Application no: 18/CH0010/Preapp

Location: Land at Promised Land Farm, Wendlebury Rd, Bicester OX25 2PA.

Transport Schedule

Comments below are in response to both the transport pre-application enquiry made directly to OCC and the CDC pre-application (Ref: 18/00287/PREAPP).

JOB TITLE		CLIENT	
CATALYST BICESTER		ALBION LAND	
DRAWING TITLE			
WENDLEBURY ROAD FOOT/CYCLEPATH ENHANCEMENT WITH HEALTH AND RACQUETS CLUB			
SCALE	DRAWN BY	DATE	DRAWING No
1: 500@A1	RJM	03/05/19	19539-12-01
			REVISION
			B

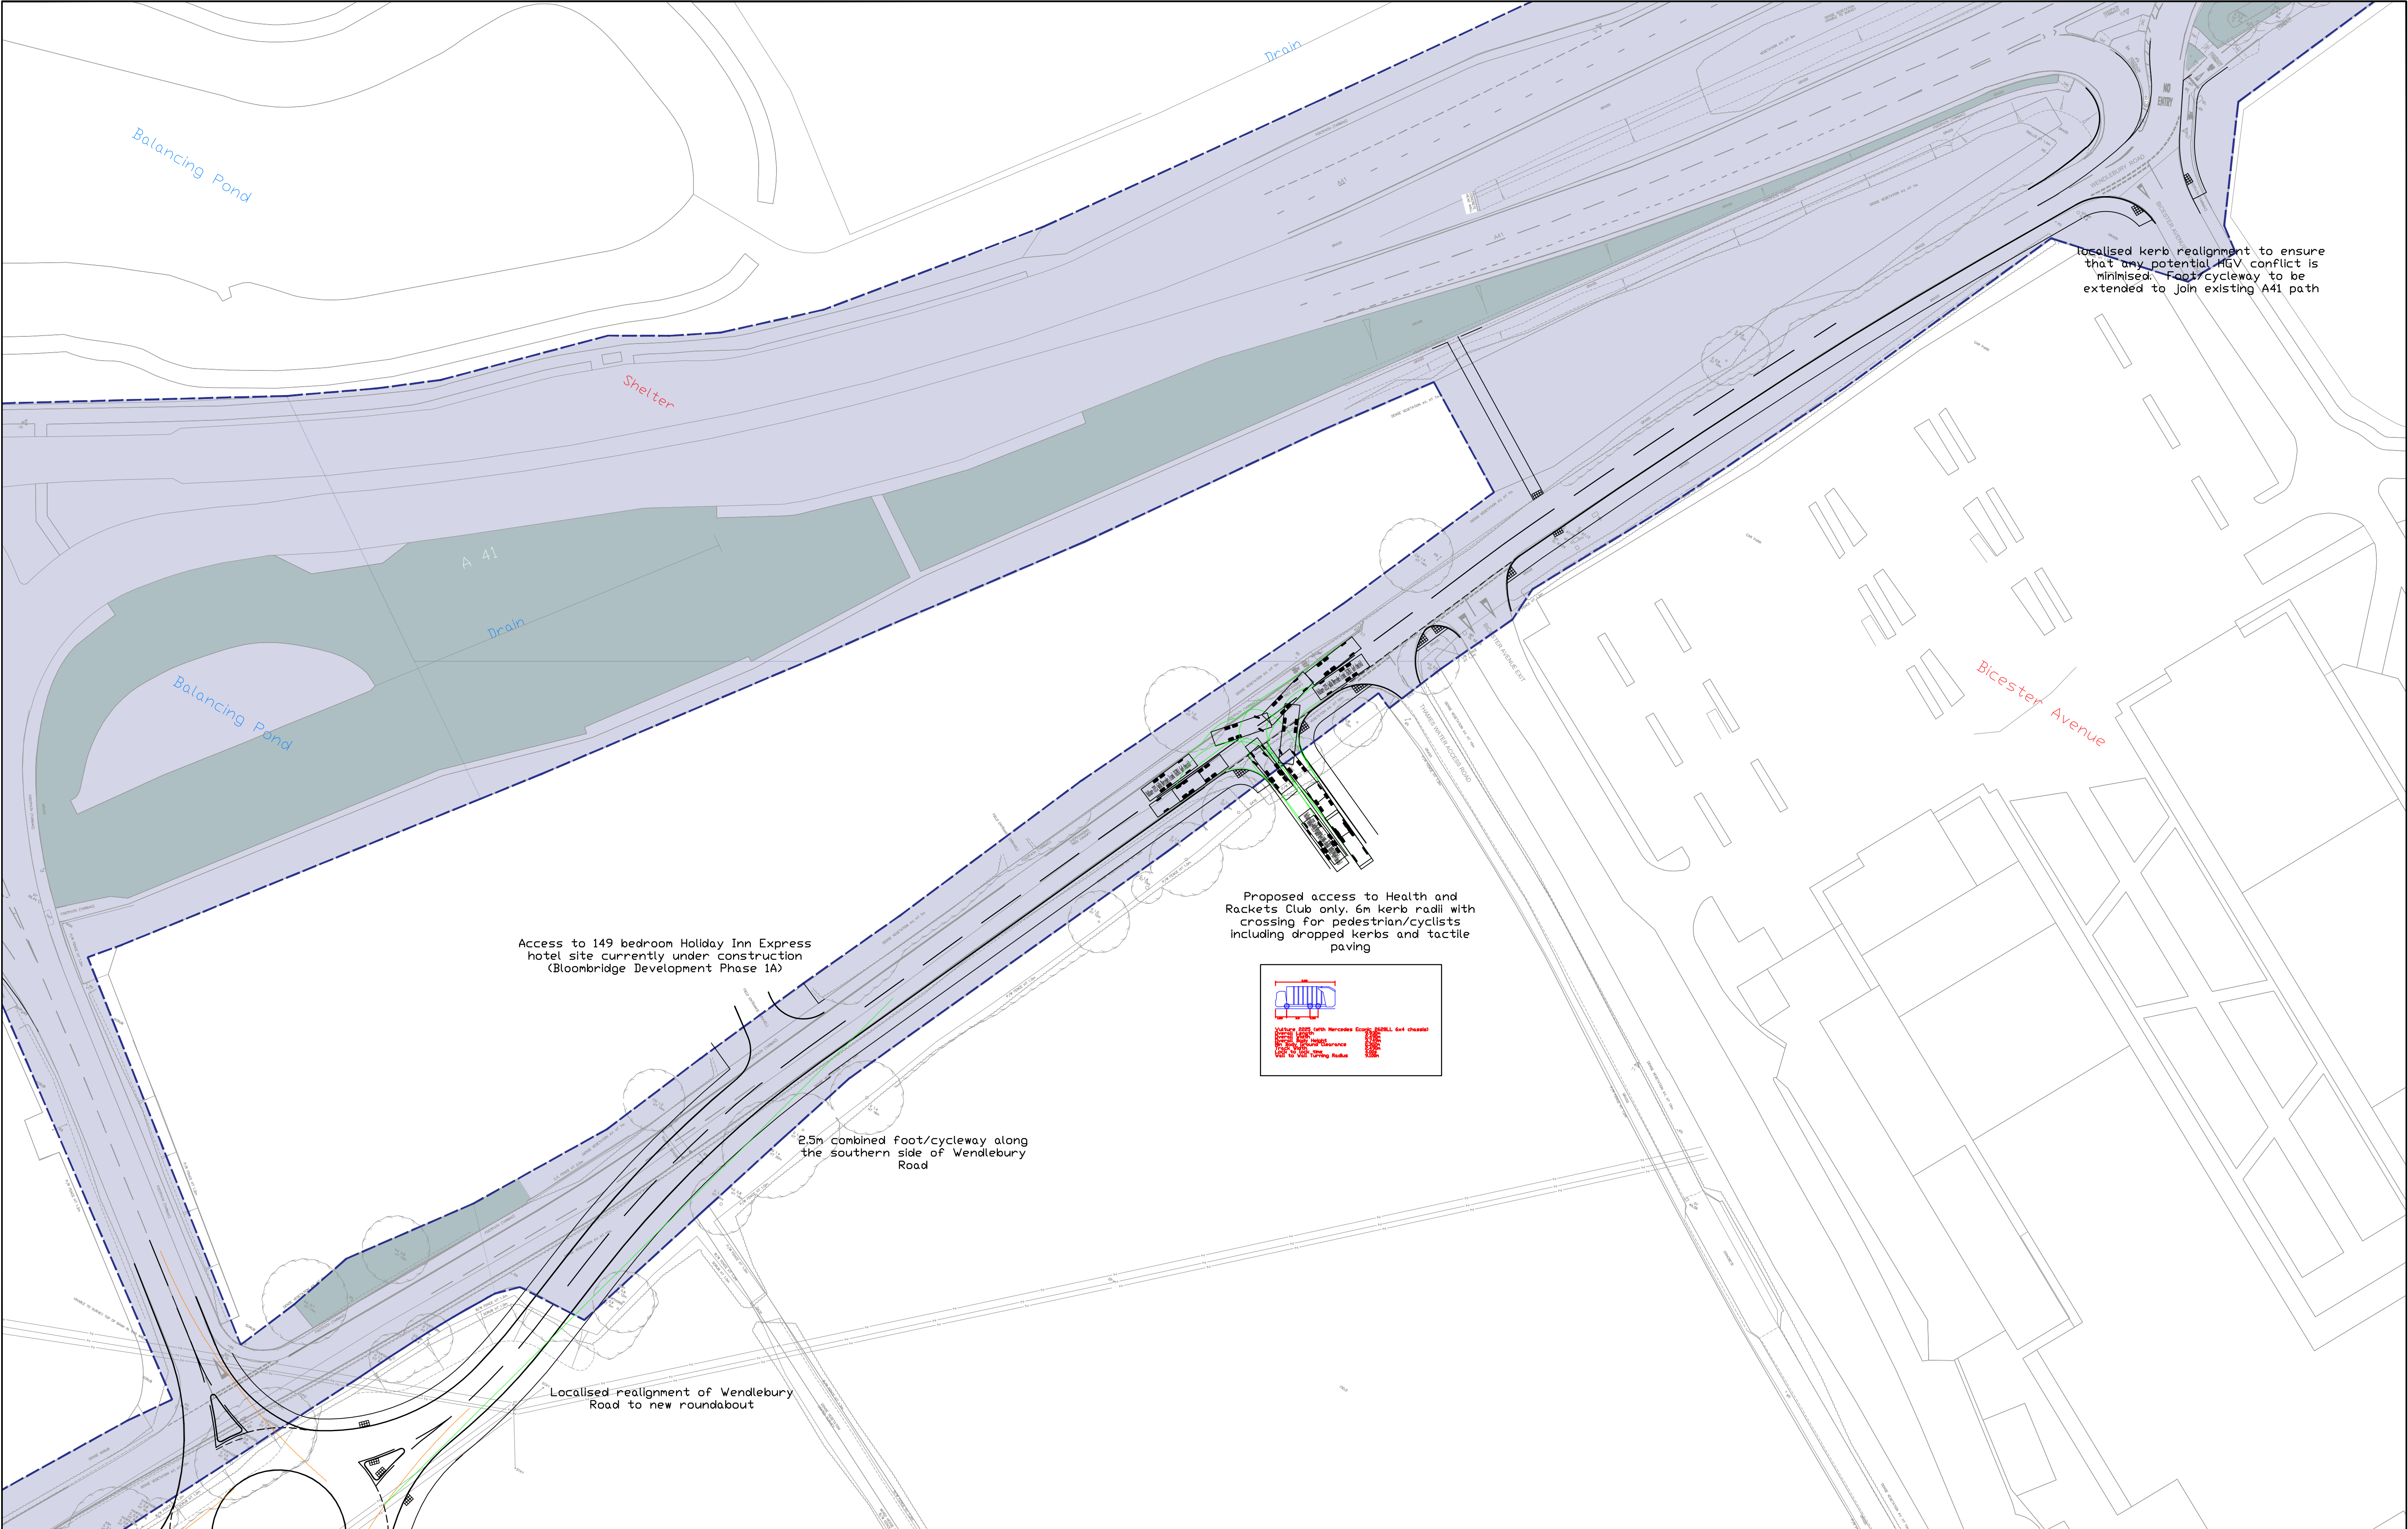
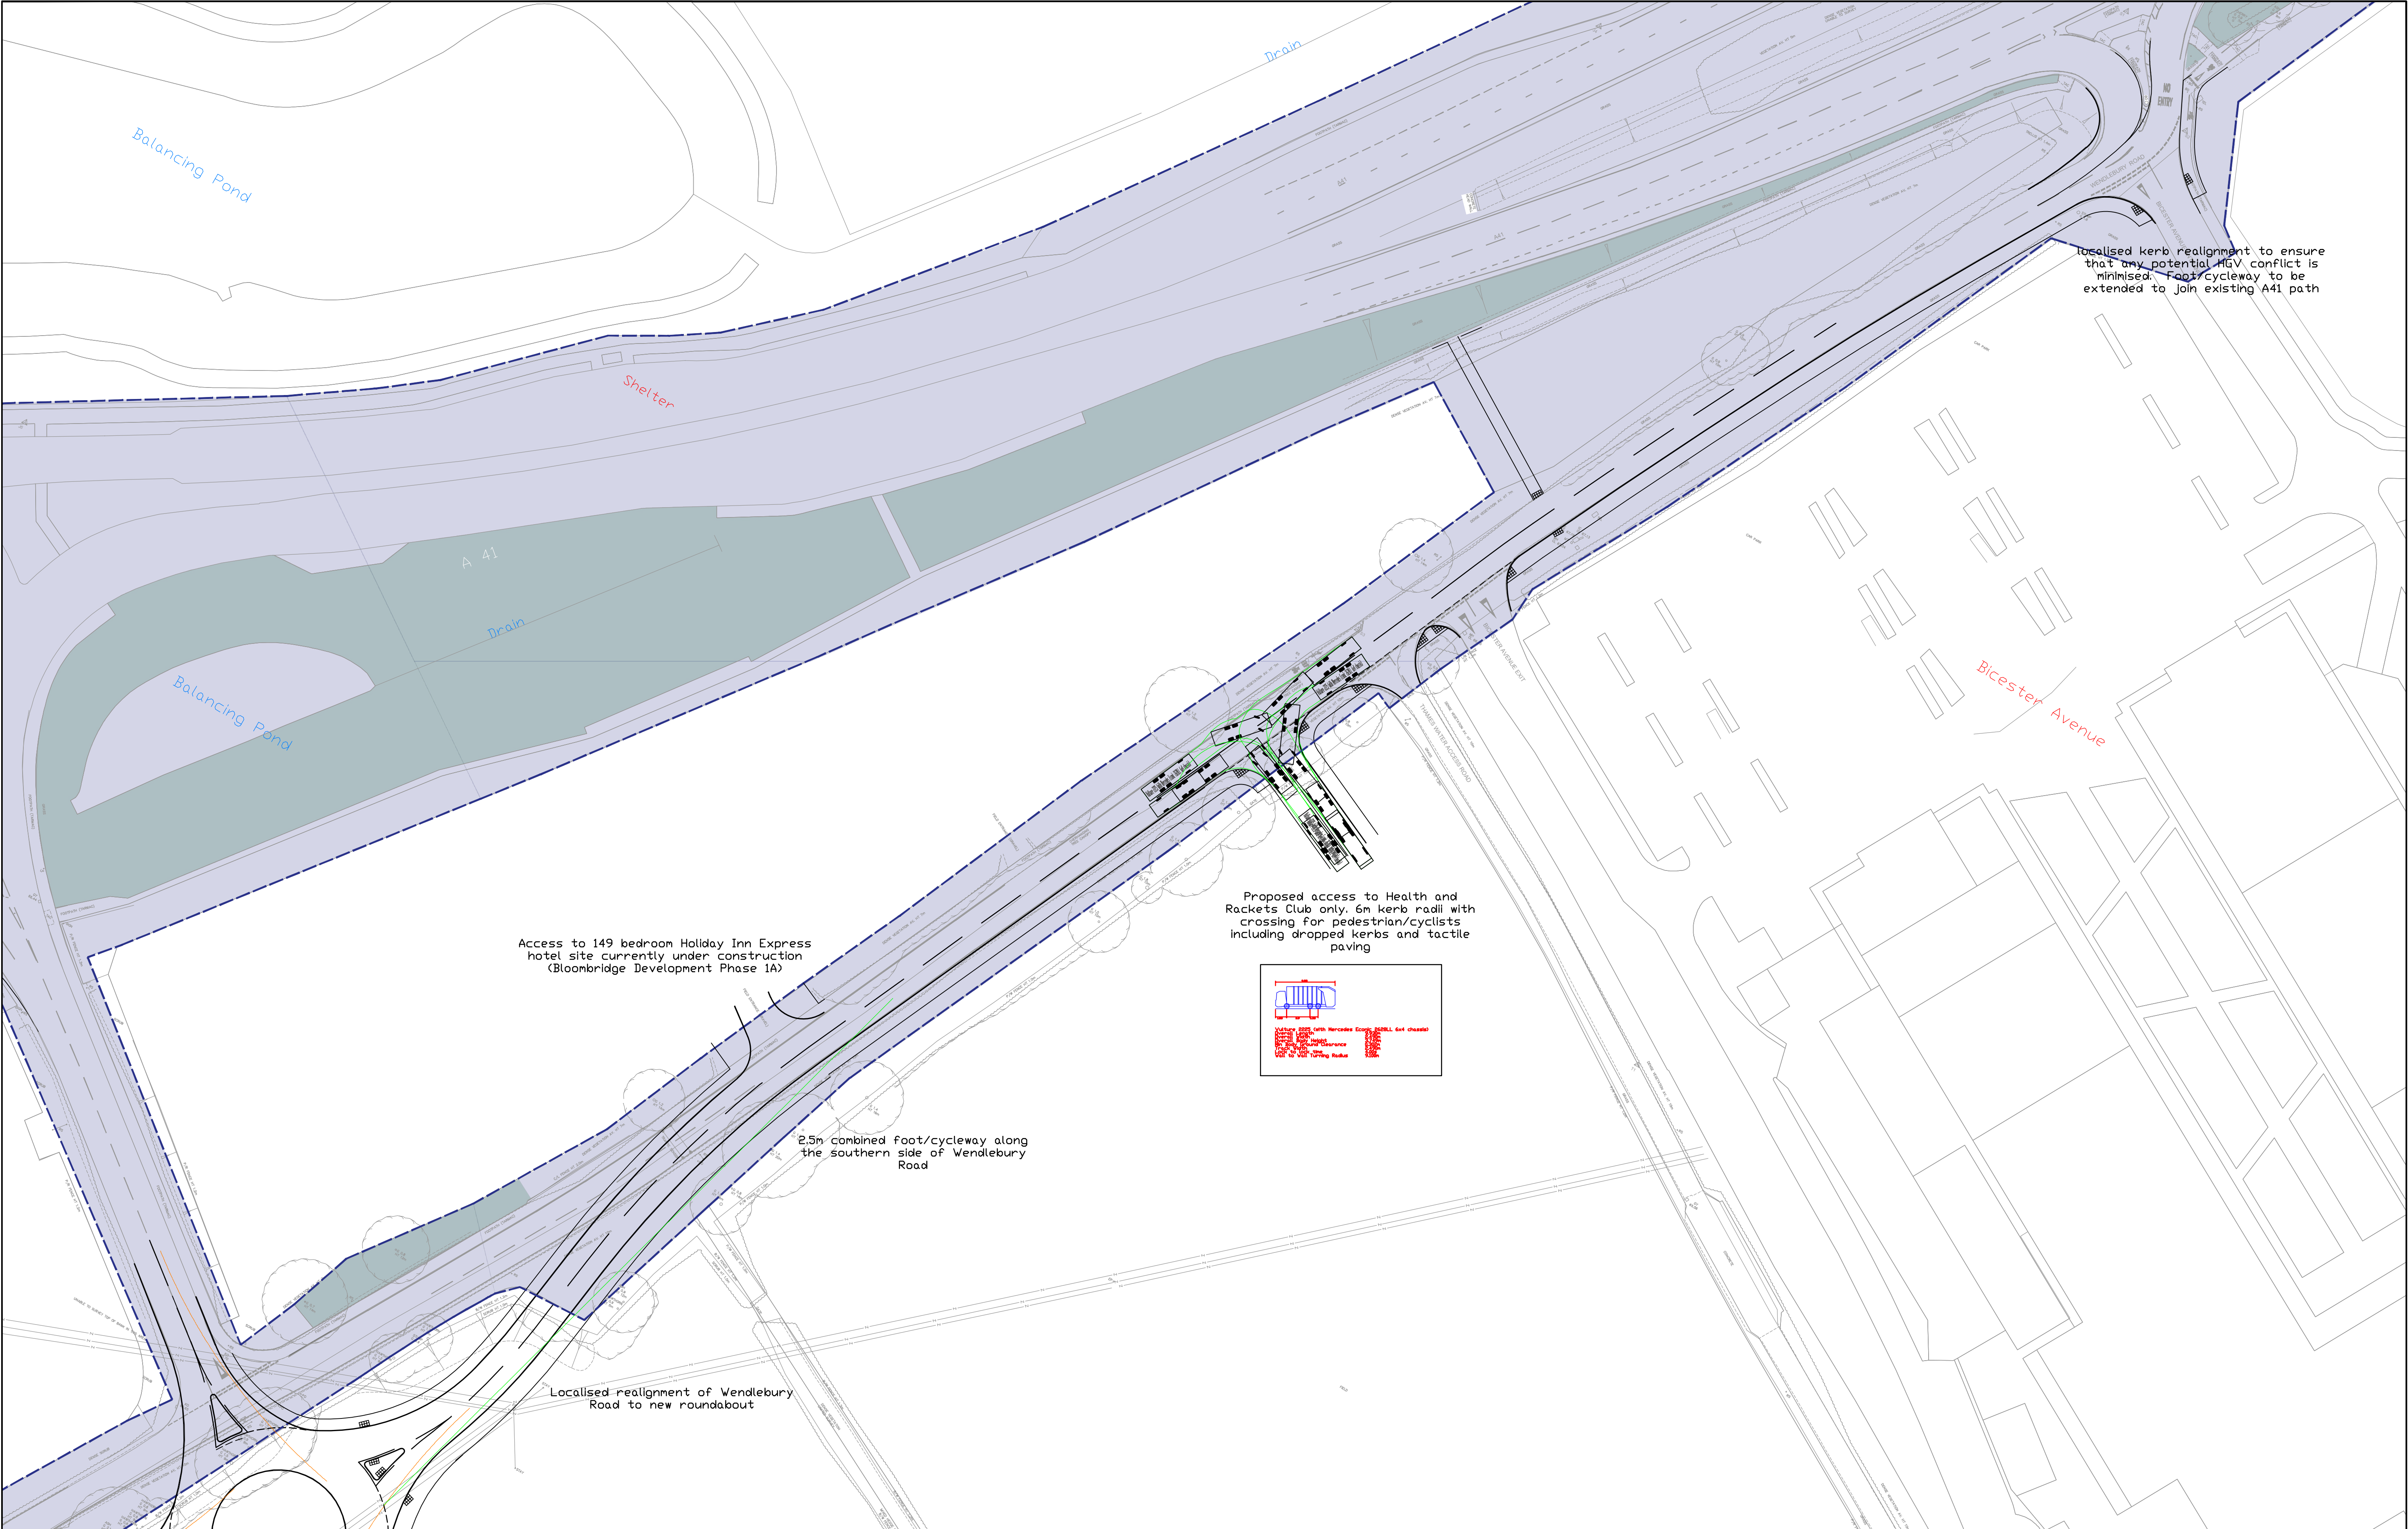
Although provision has been provided for those walking immediately out and into the site, the application needs to provide continuous pedestrian facilities/routes from the existing highway: directly towards the bus stops on the A41, and northwards along Wendlebury Road to its junction with the A41.

Wendlebury Road is a Sustrans cycle route (NCN51) and consideration will need to be given to how the development proposals would tie into the existing cycle and pedestrian infrastructure without compromising safety and operation of the NCN51,

taking into account the increased volume of traffic. I suggest that the application considers a cycle infrastructure provision along the site frontage to mitigate for the increased traffic. A cycle and pedestrian link should also be provided directly into the proposed John Lloyd centre from Wendlebury Road, to minimise walking and cycling distance for users and staff, thereby encouraging sustainable travel.

JOB TITLE CATALYST BICESTER		CLIENT ALBION LAND	
DRAWING TITLE WENDLEBURY ROAD SITE ACCESS ROUNDABOUT			
SCALE 1: 500@A1	DRAWN BY RJM	DATE 03/05/19	DRAWING No 19539-12-02
REVISION B

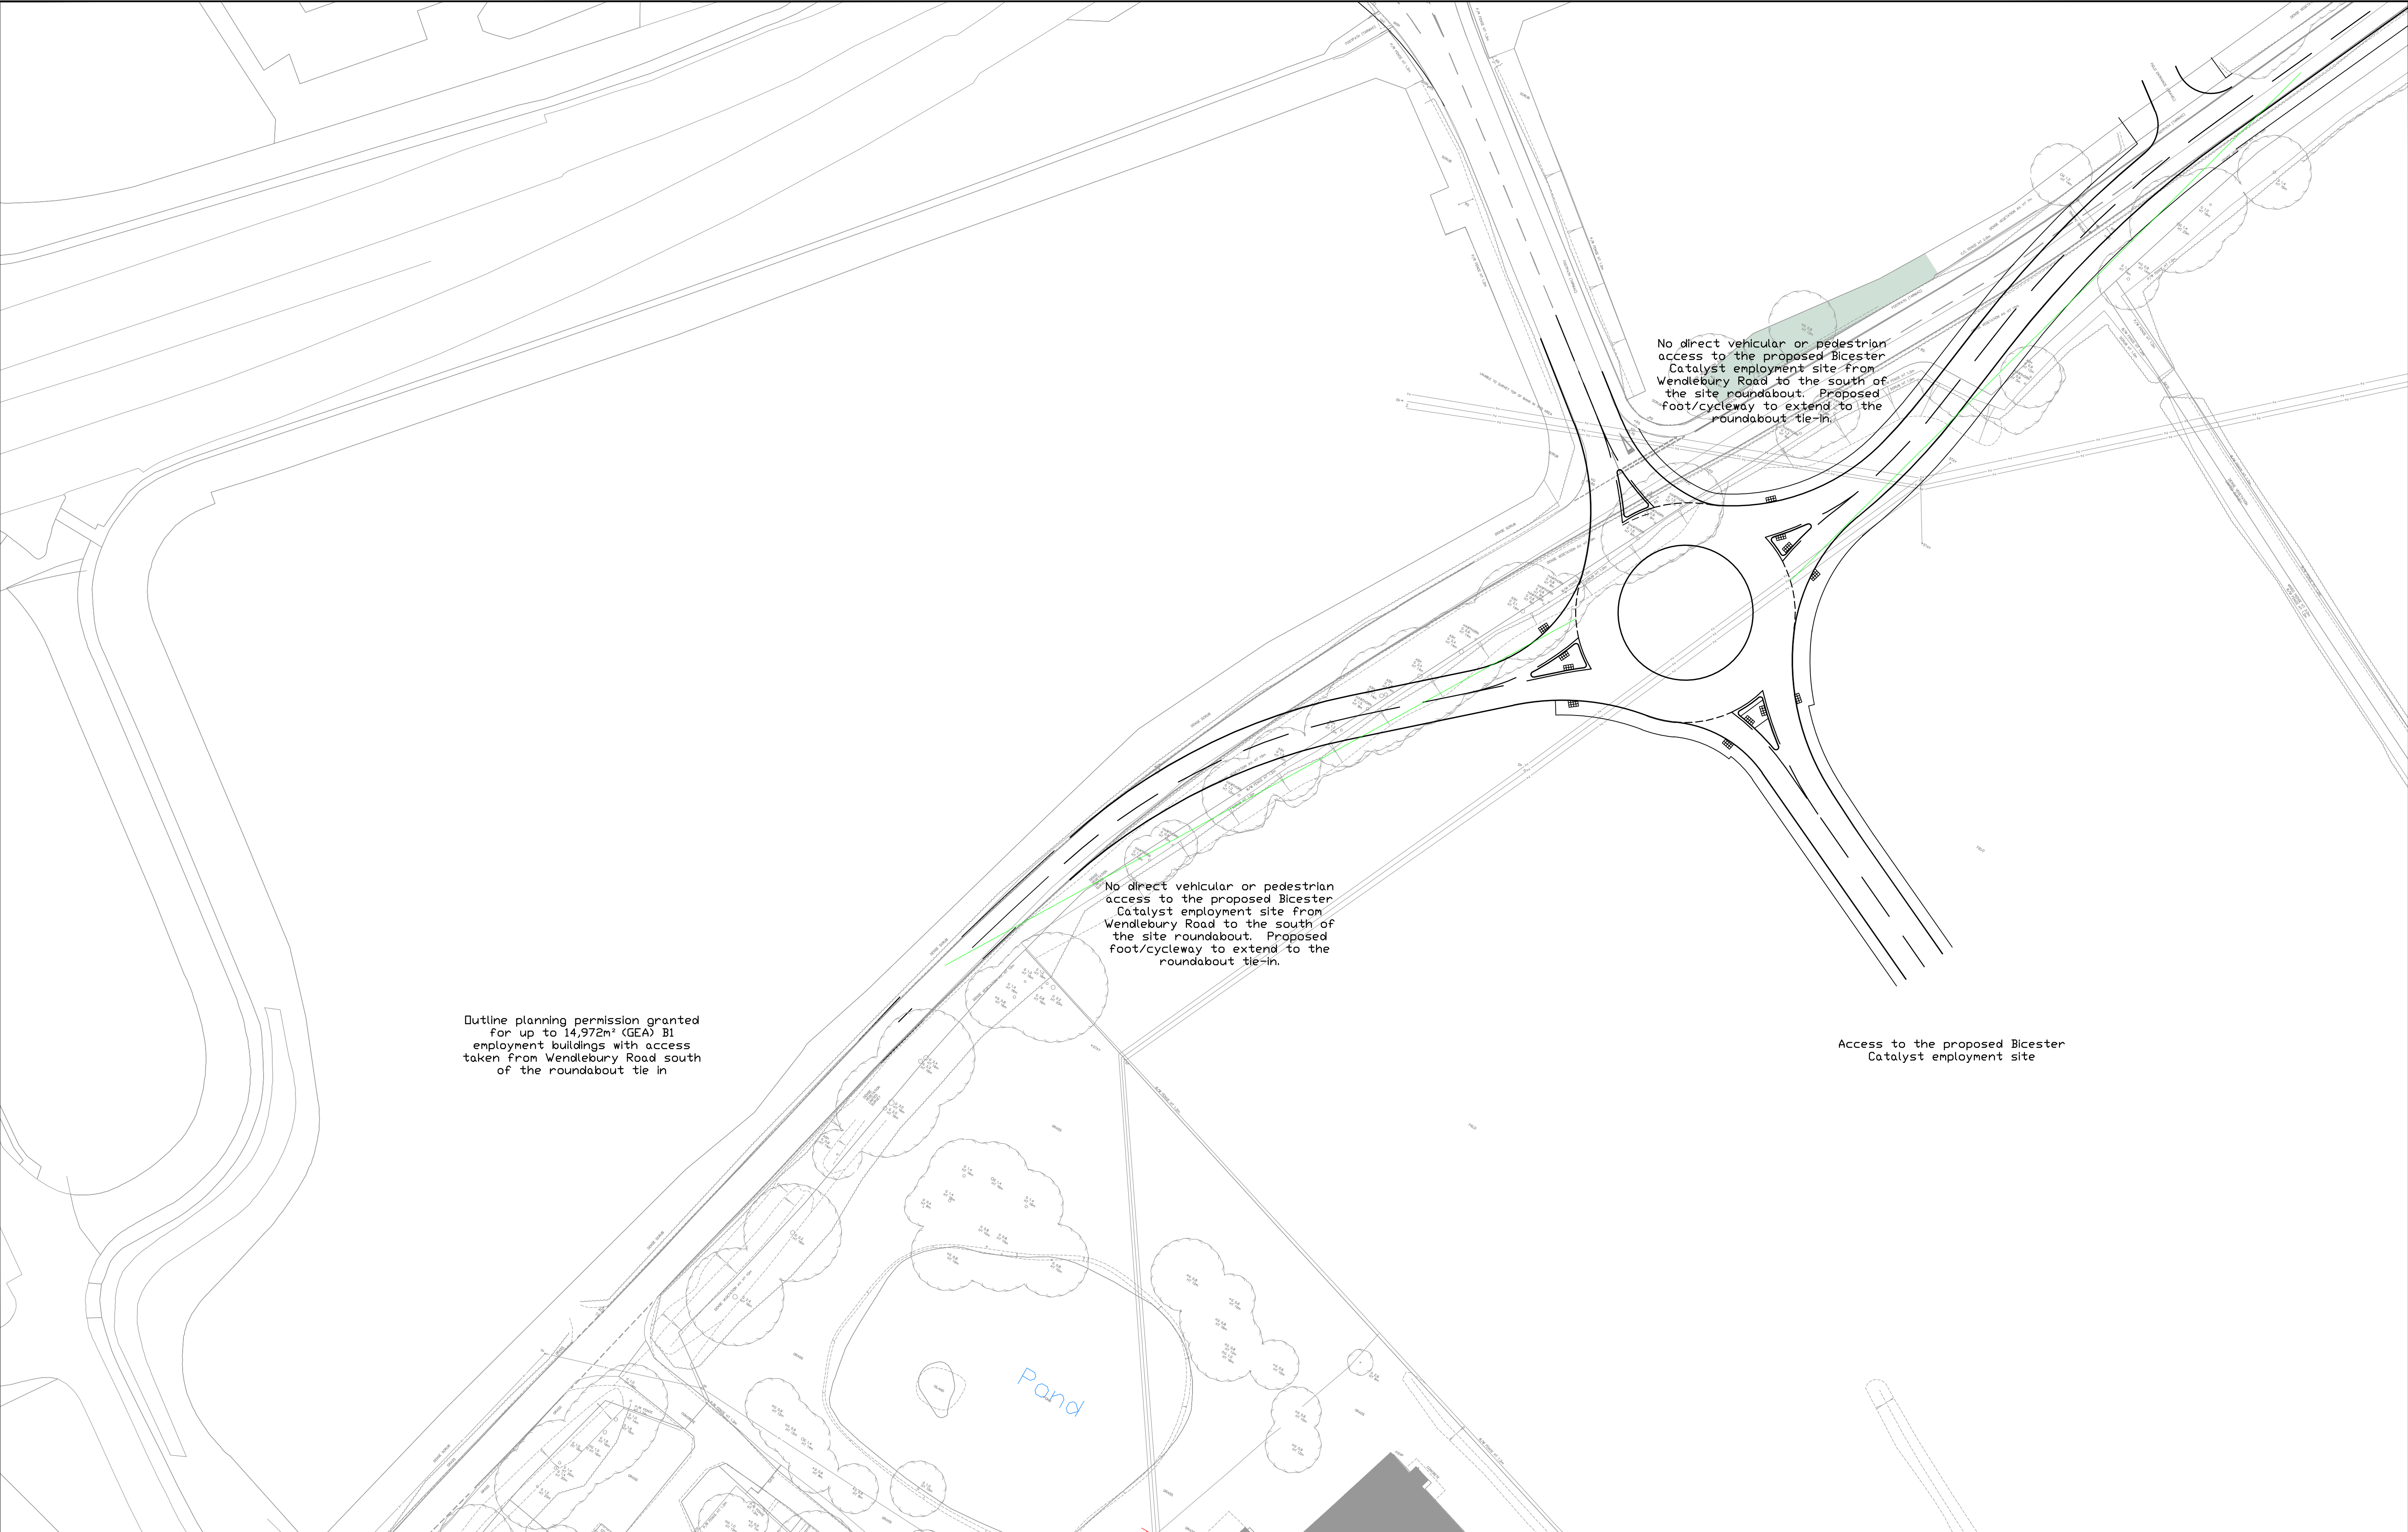
Para 8.4 suggests that the proposed roundabout that would form access onto Wendlebury Road has already been capacity tested which has confirmed that traffic can be accommodated at the roundabout. Modelling results are hence required for this roundabout.
